CITY OF ALBUQUERQUE

**Re: Liberty Dialysis-Rio Rancho, 5751 McMahon Blvd.
Final Certification Of Occupancy
Engineer's Stamp Date: 11/05/2013 (A11/D013)
Certification Date: 09/24/2013**

Re: Additional Information for Drainage Certification to obtain Permanent CO
5751 McMahon Blvd. Liberty Dialysis - Rio Rancho (A-11/D013)

CONCEPTUAL GRADING PLAN

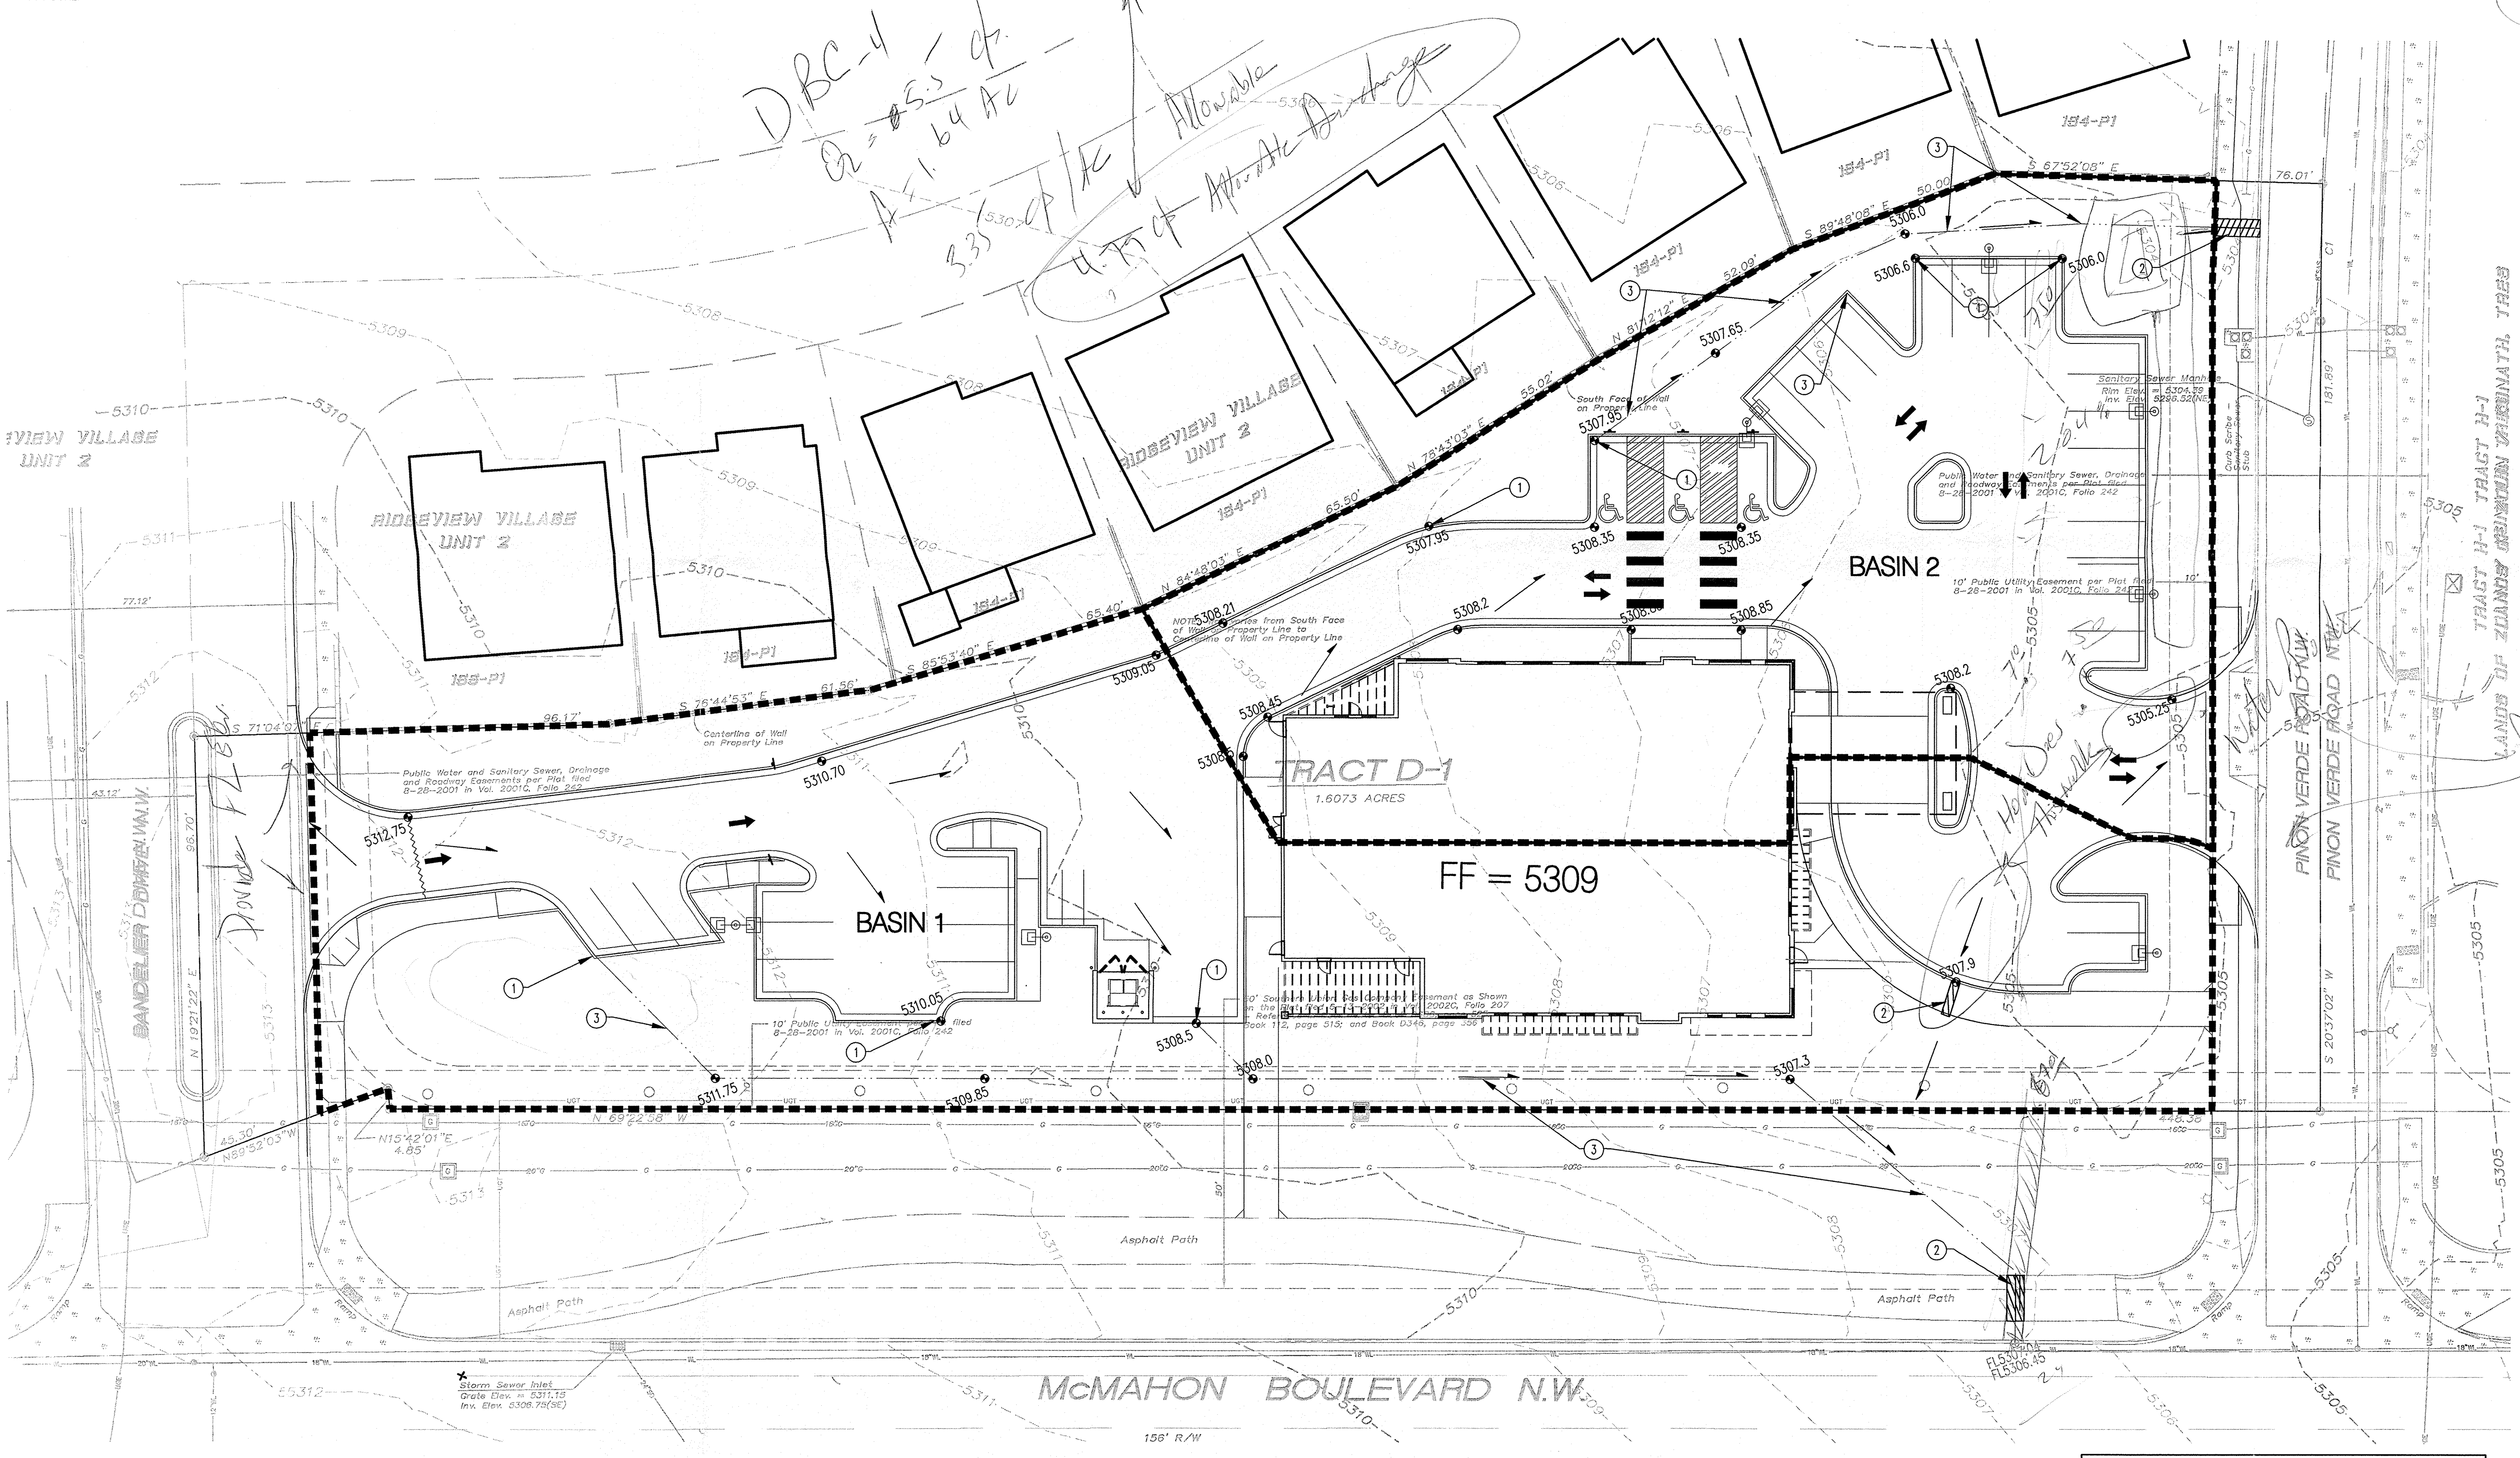
Per our discussion 9/30/2013 concerning your site visit of the same day, you requested that the contractor complete the following items prior to issuing a permanent CO:

1. Provide a more defined swale from the curb opening to the invert of the sidewalk culvert at the northeast corner of the site.
2. Ensure all riprap downstream of curb openings was constructed such that it is lower than the elevation of the curb opening and positive drainage occurs, preventing ponding within the parking lot.

Based on the attached pictures, the swale has been defined appropriately. In addition, it was determined that the contributing basin is less than 1 cfs and the swale constructed has the capacity for this drainage at a 4% slope.

The contractor has also informed me that they have lowered the rock in the areas you defined during our conversation and that positive drainage occurs within these areas as well.
